From: Thomas Callaway
Sent: 22 October 2014 13:36
To: Planning.Responses
Subject: RE: Planning Consultation on BE/121/14/DOC

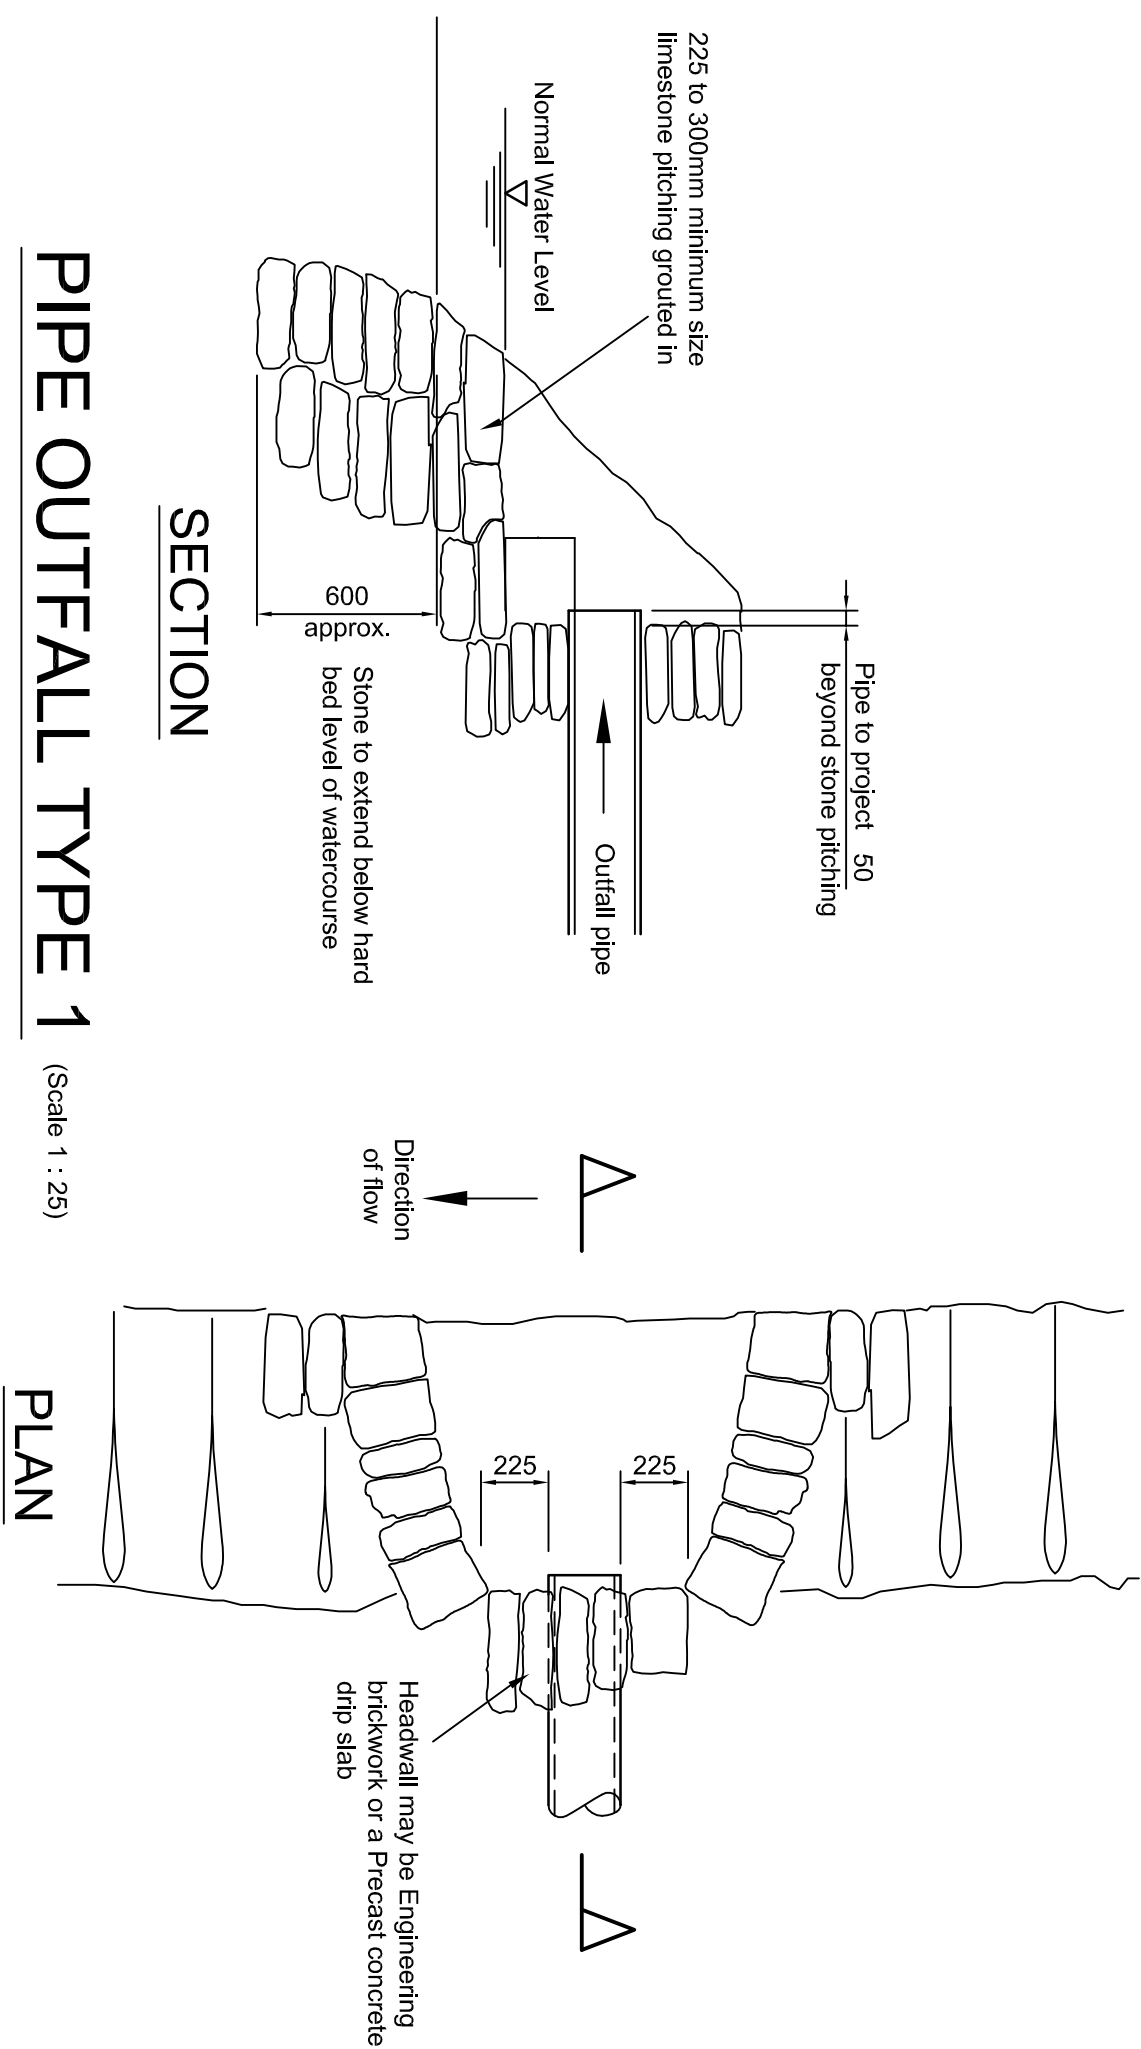
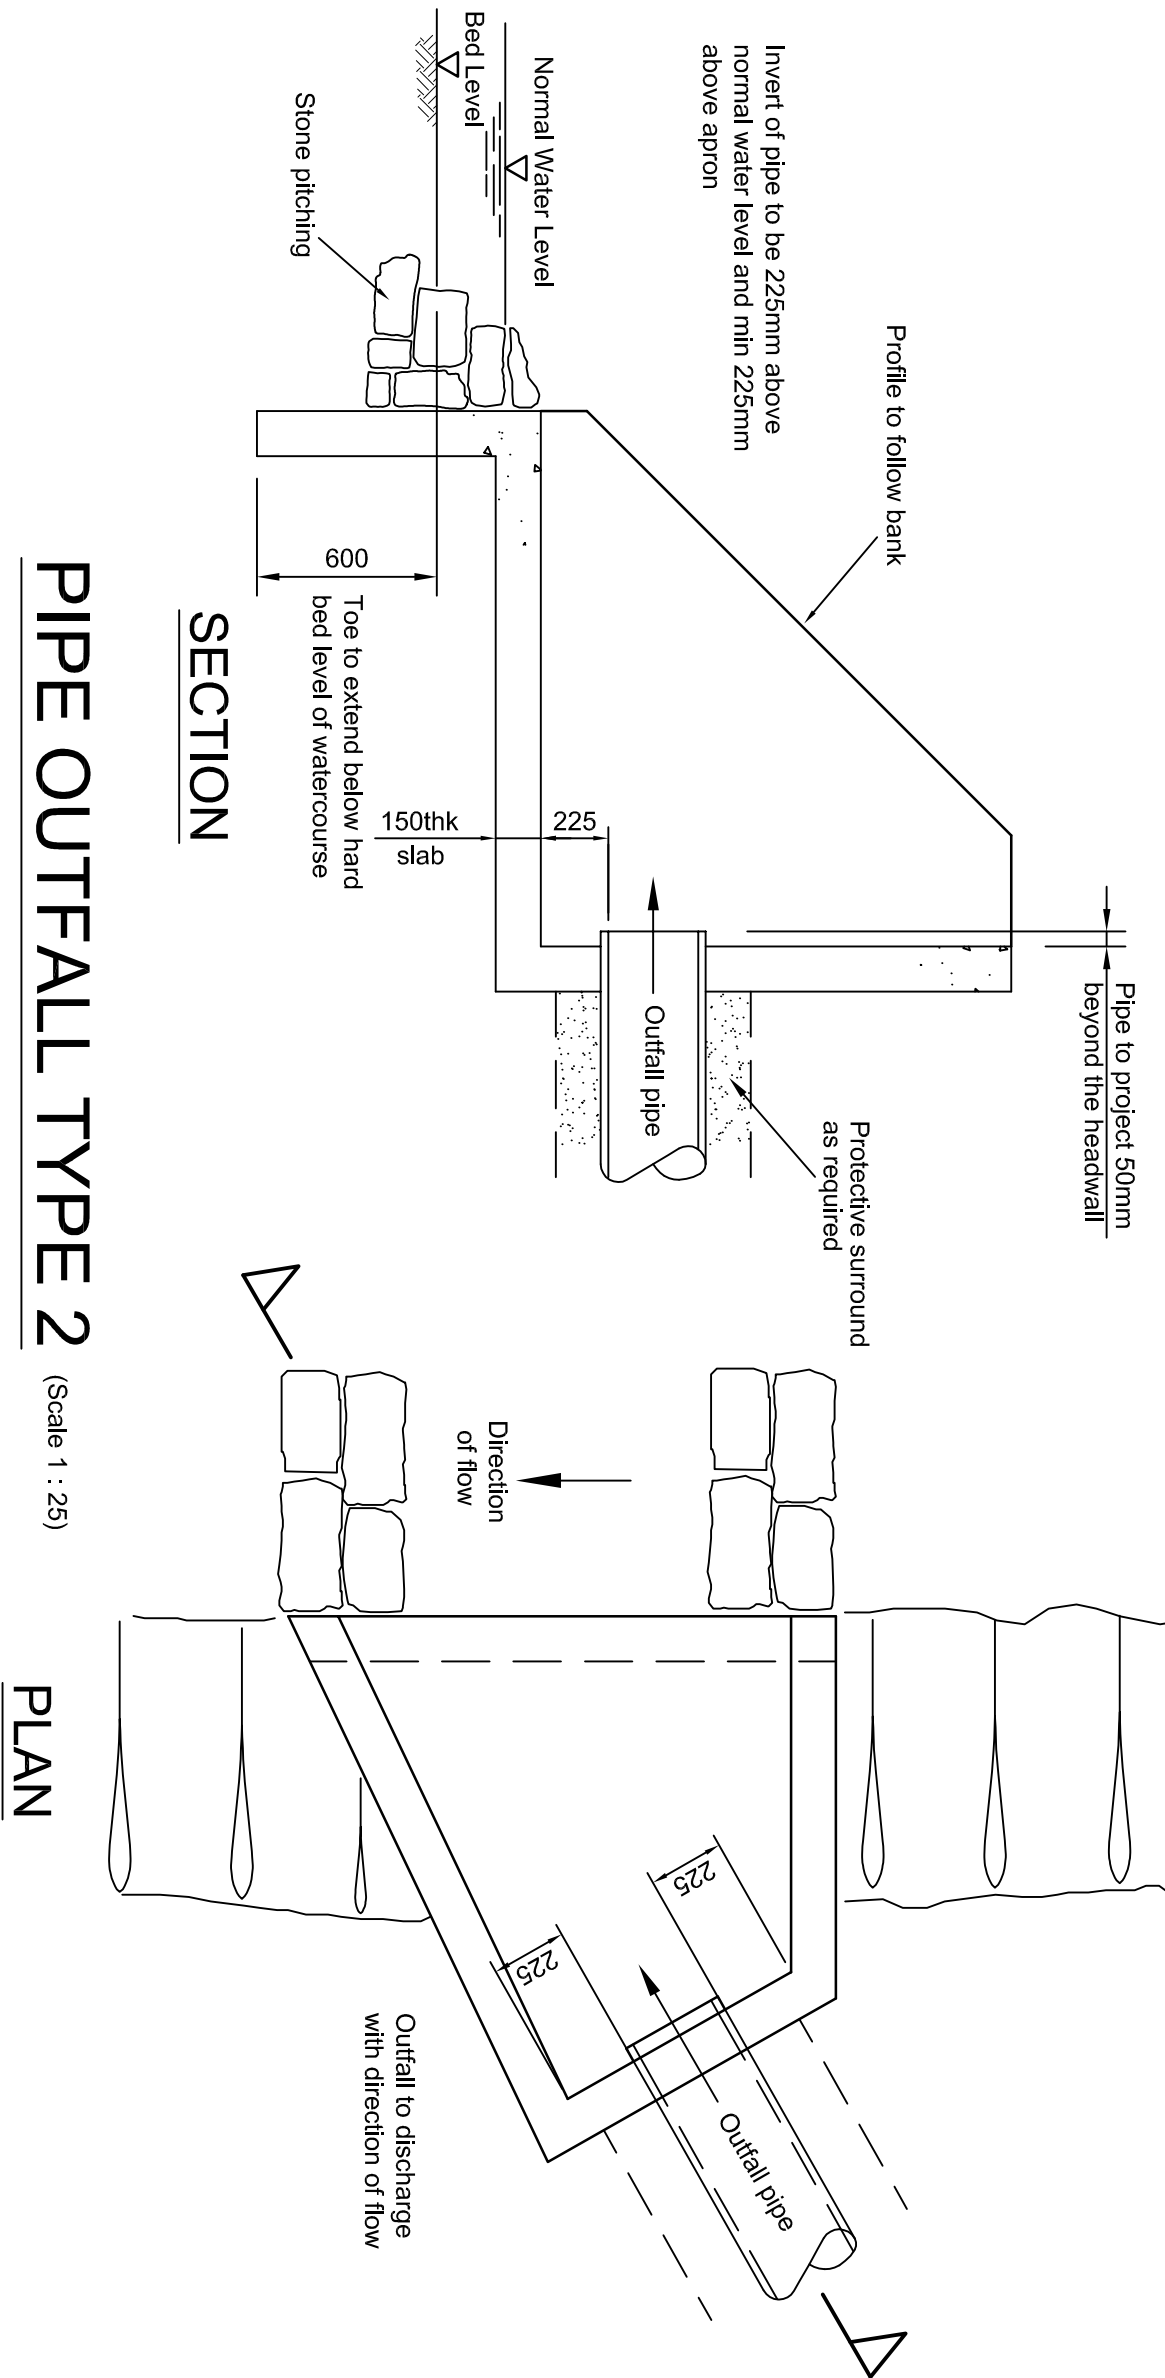
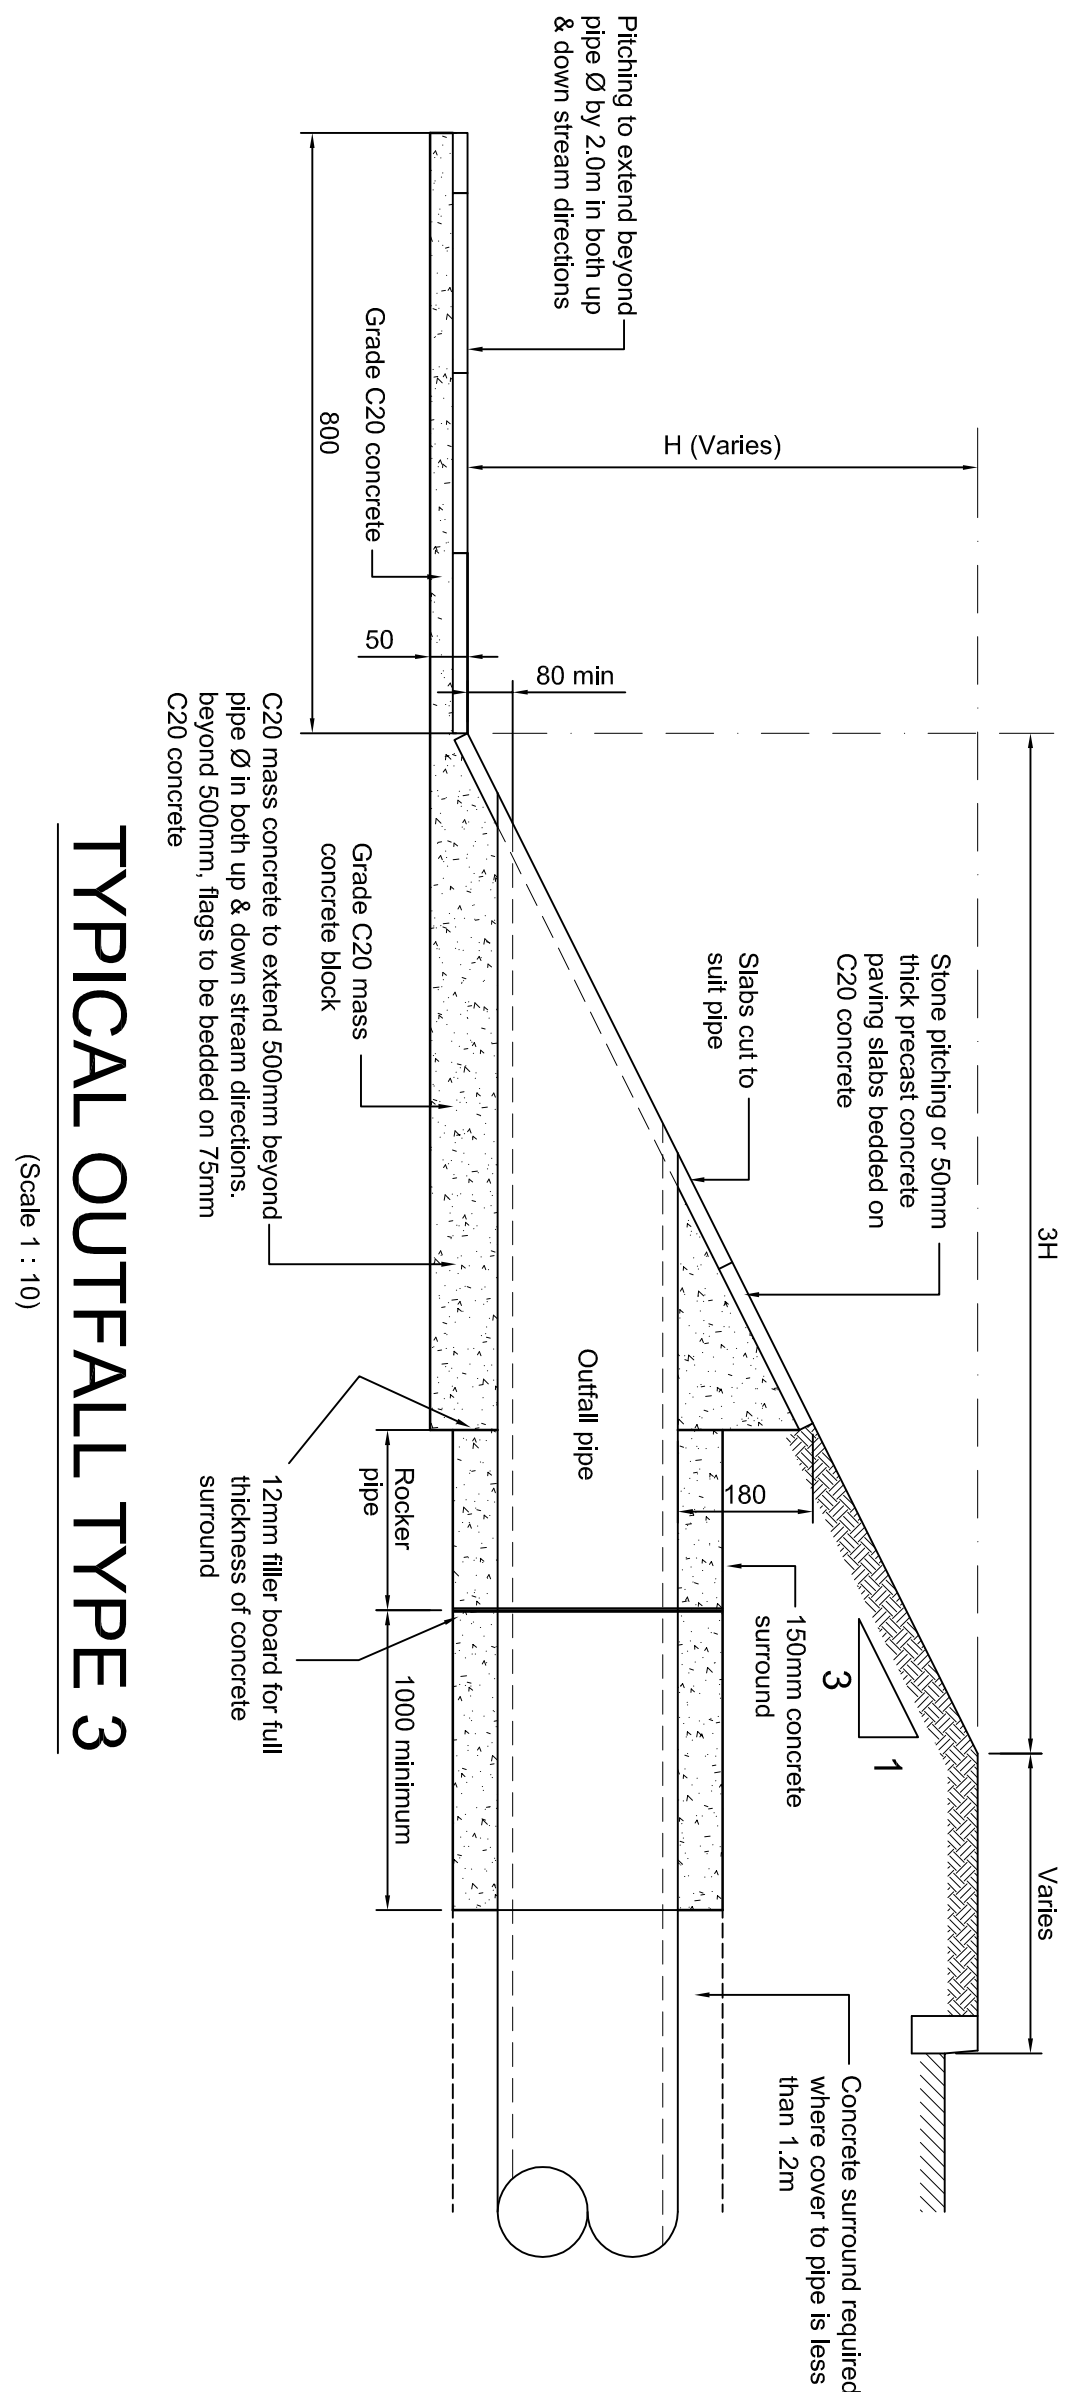
If the pond is to remain, the outlet should be more angled in line with the flow in the ditch it is discharging to. Construction drawings are still required to show the outlet, flow control and how the pond liner is to resist floating when groundwater is high (ensuring the design storage is retained).

PLAN ON ATTENUATION POND  
Scale 1: 500

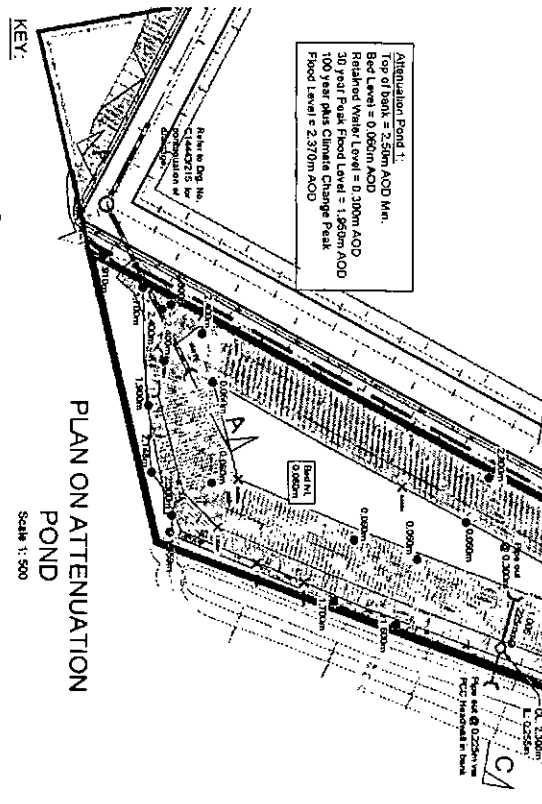
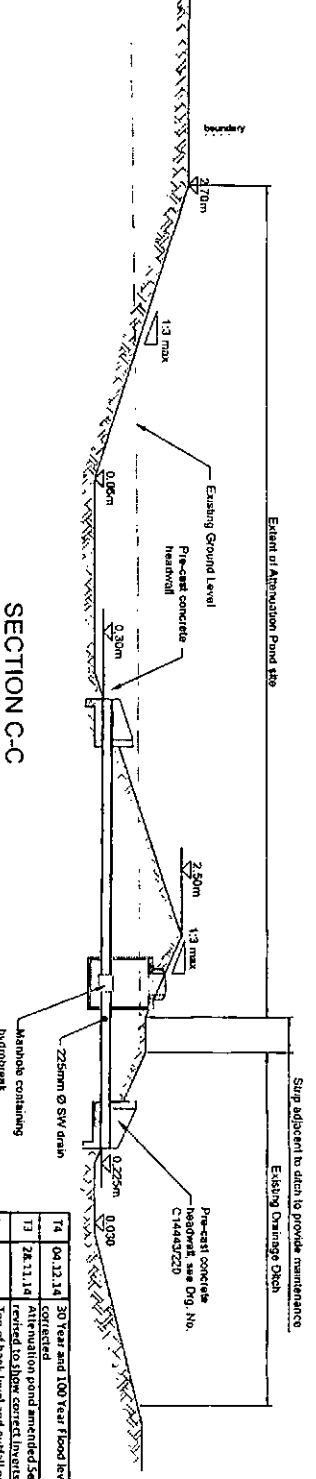
The pond is in a cramped position and the freeboard for a 1 in 100 year storm event plus climate change is only 50mm. There should be a minimum freeboard of 300mm, and also there should be a 3 metre accessible easement between the pond and railway ditch for maintenance of both features. If permeable paving is incorporated, less storage will be required in the pond and ponding issues in the car park for extreme events will be reduced.
